Ribble Valley Borough Council
Housing & Development Control

Application no: **3/2020/0911**

Address: **Shackletons Garden Centre Ltd Clitheroe Road Chatburn BB7 4JY**

Proposal: **Proposed two-storey extension to rear and re-modelling of home and garden centre, including additional indoor and outdoor retail space and increased cafe area and play area.**

main car park entrance - large car tracking

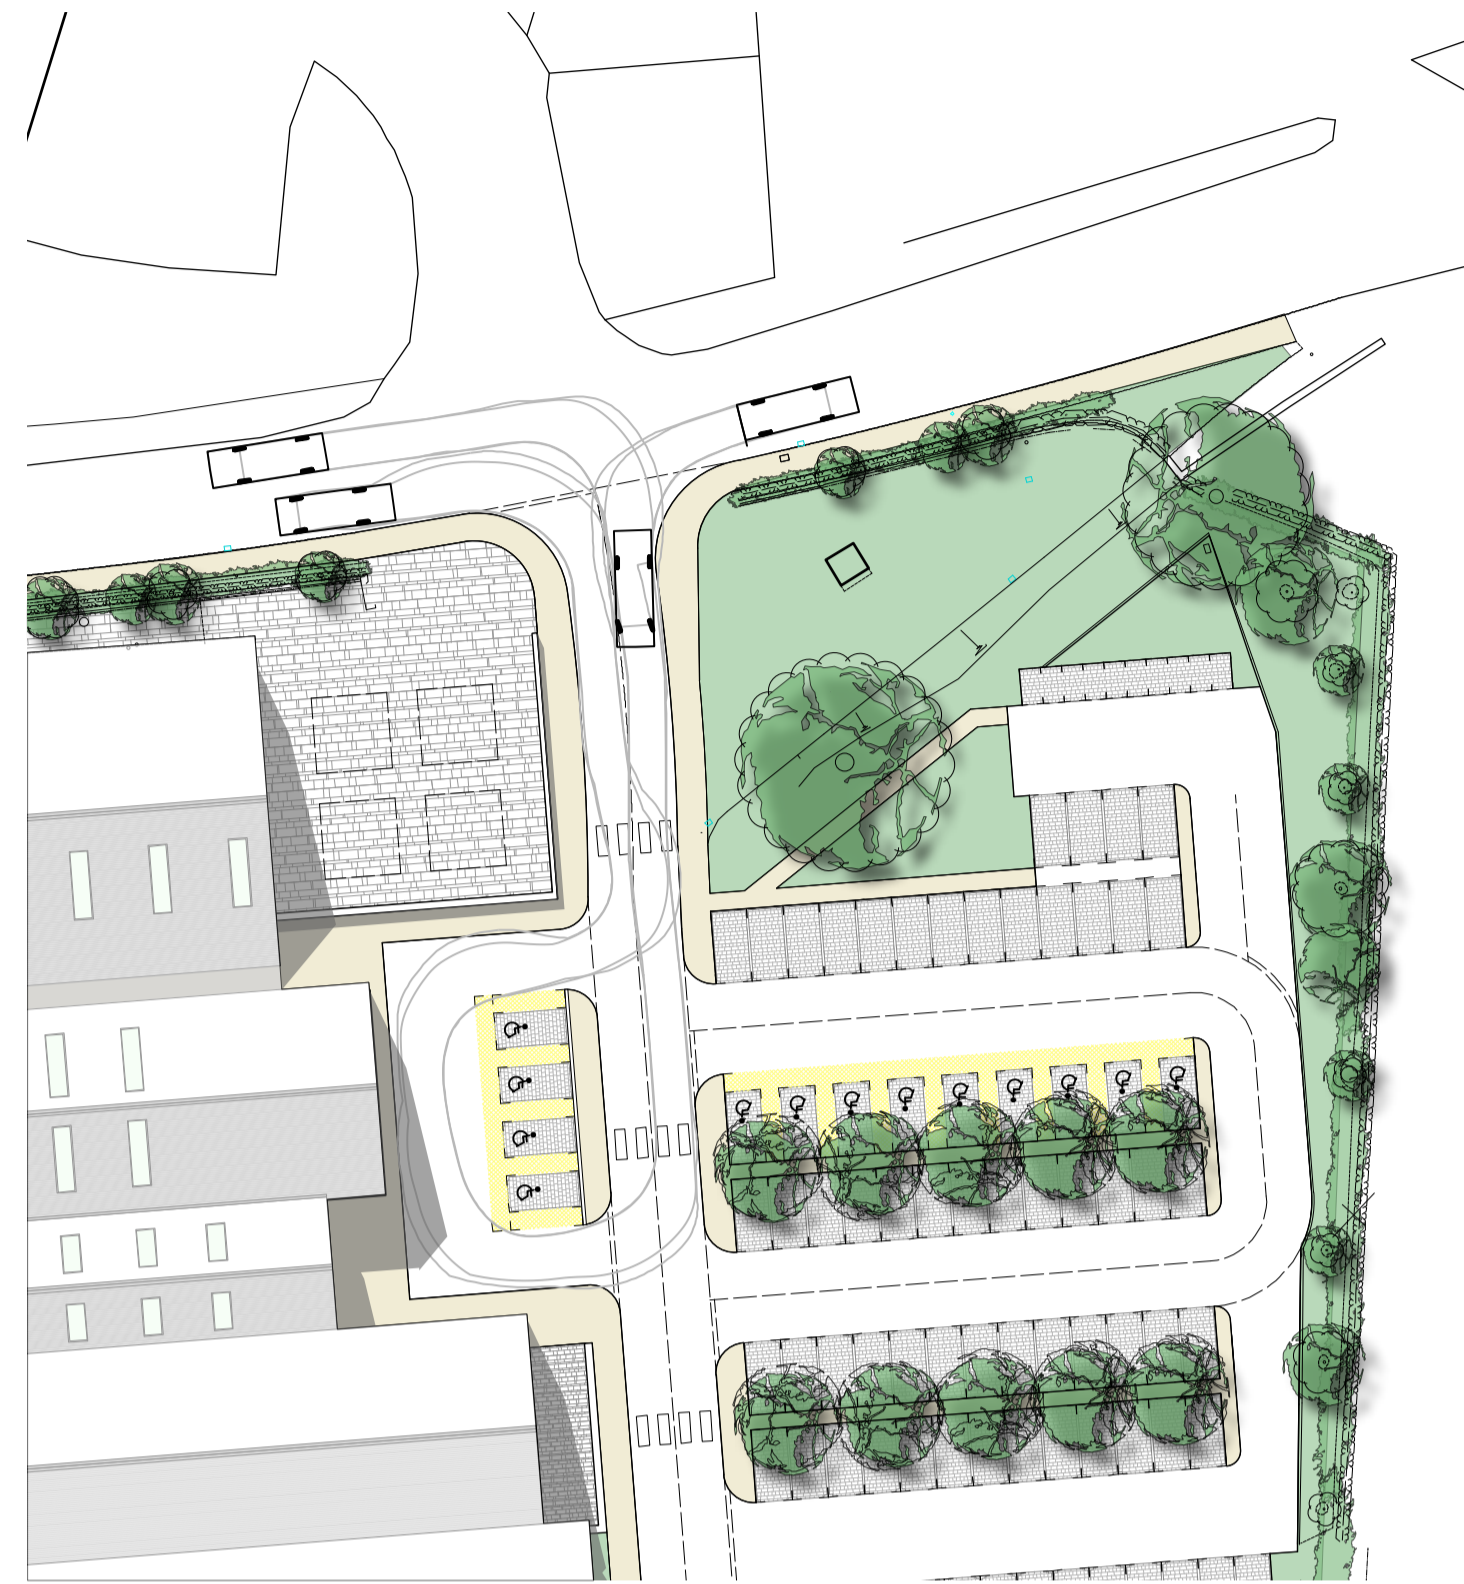
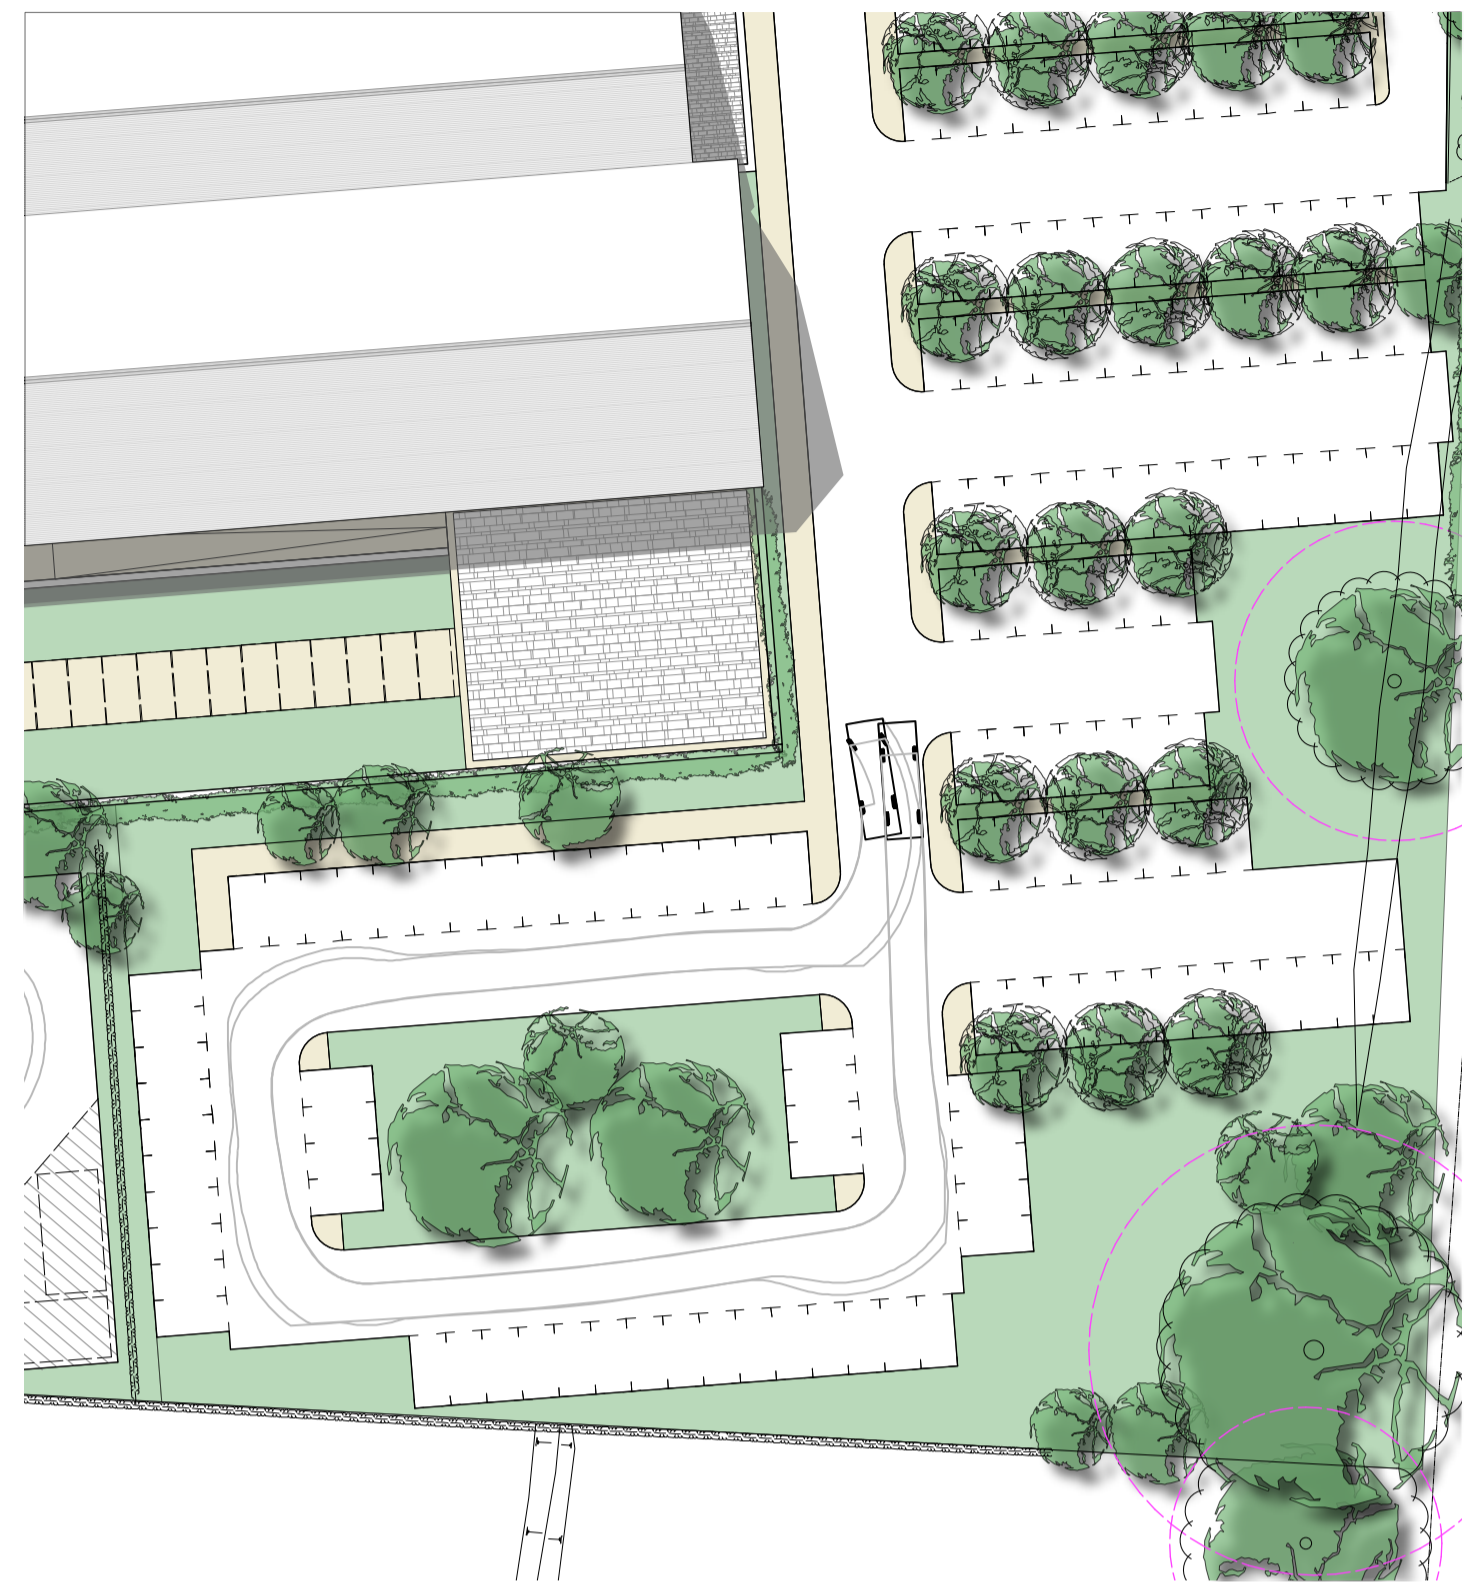
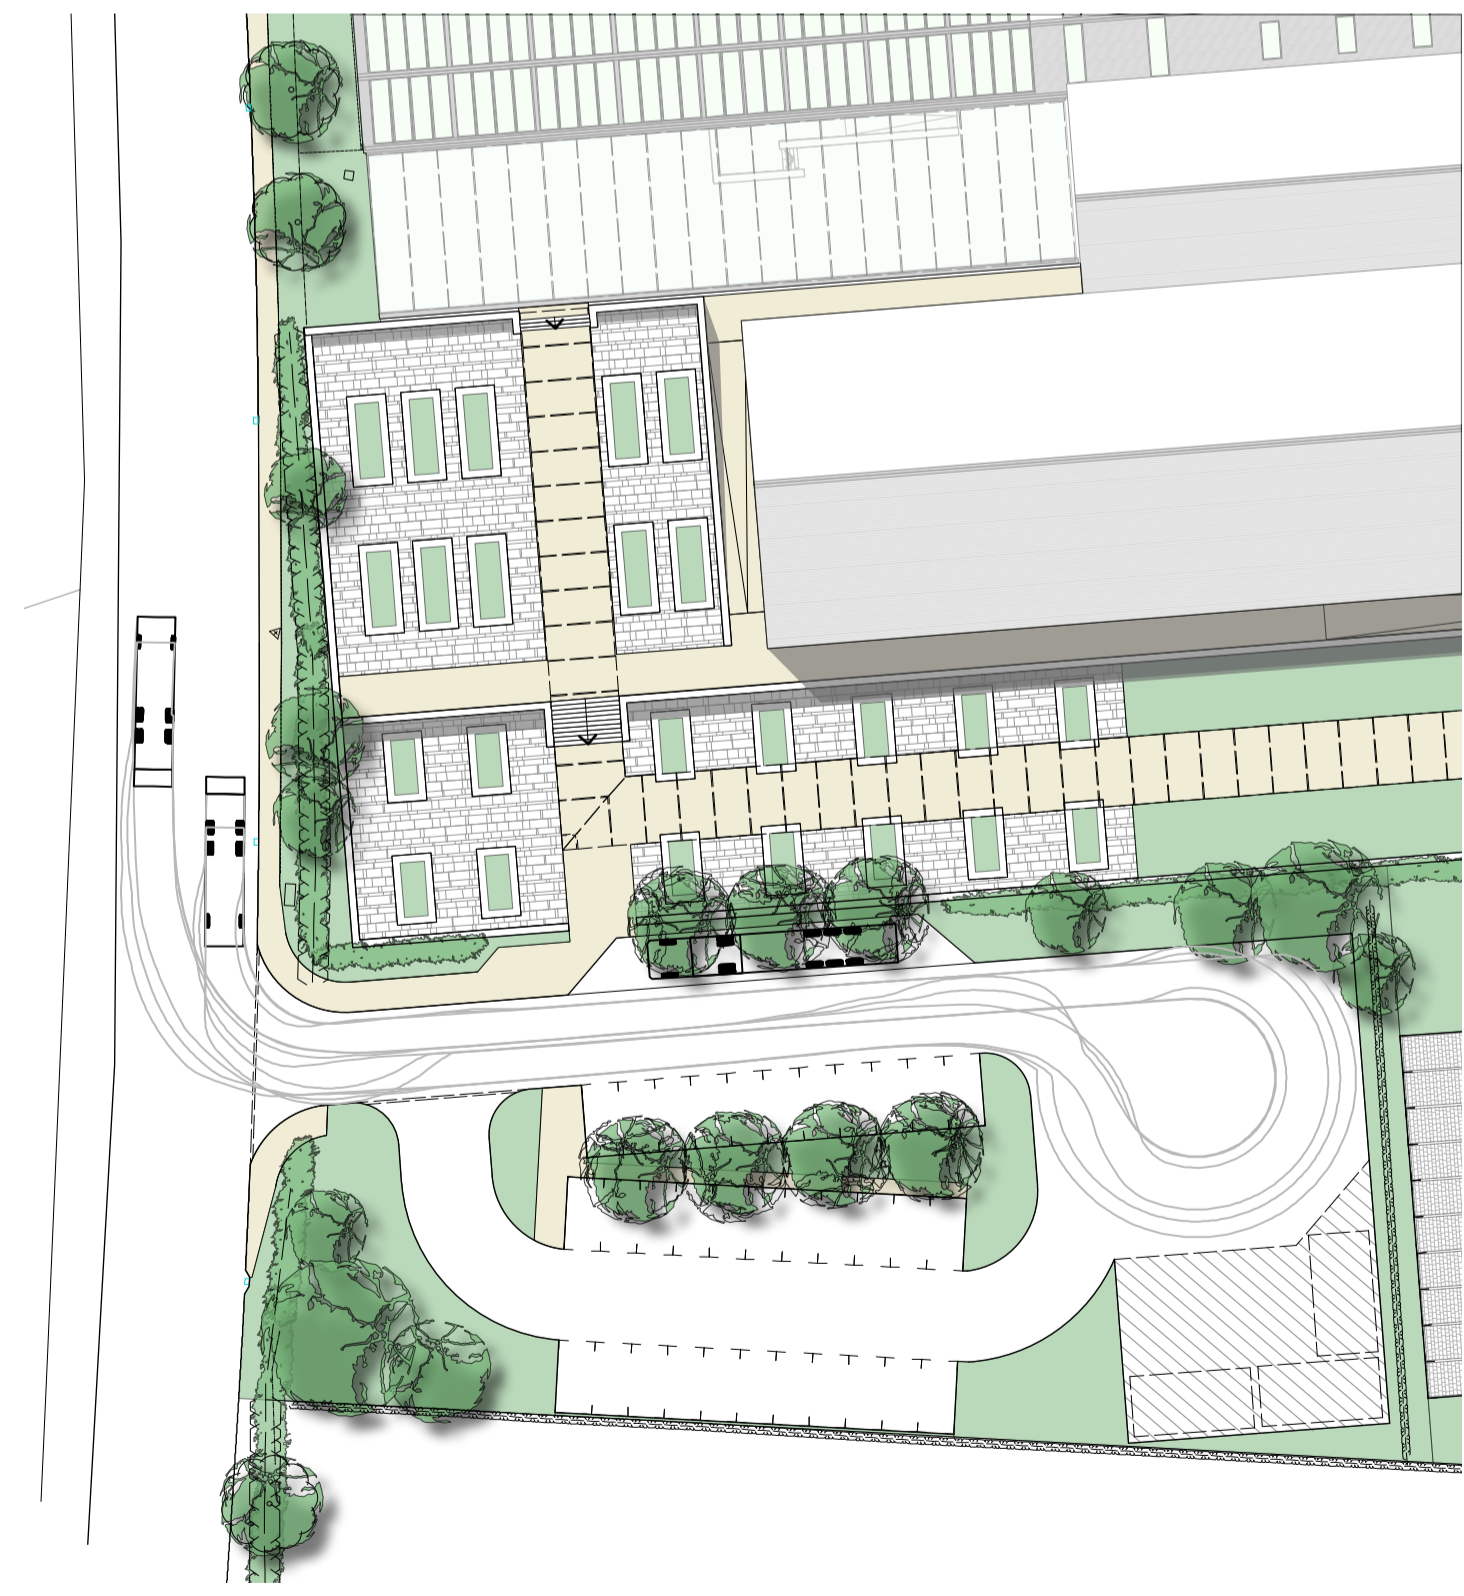
While the LHA have reviewed the drawing and the access arrangements along with the visibility splays comply with the LHAs guidance, the LHA are concerned about large delivery vehicles using the access. This is because as shown on the swept path analysis drawing on the revised plan, the delivery vehicle exiting the site and turning right onto Worston Road, overlaps the grass verge and then the footway as it exits the site. The drawing also shows its extremely narrow for delivery vehicles to enter the site, with the swept path being extremely close to the footway. Therefore, the LHA require the access and the carriageway into the site to be widened which should be shown on a revised drawing. A revised swept path analysis drawing should also be submitted.
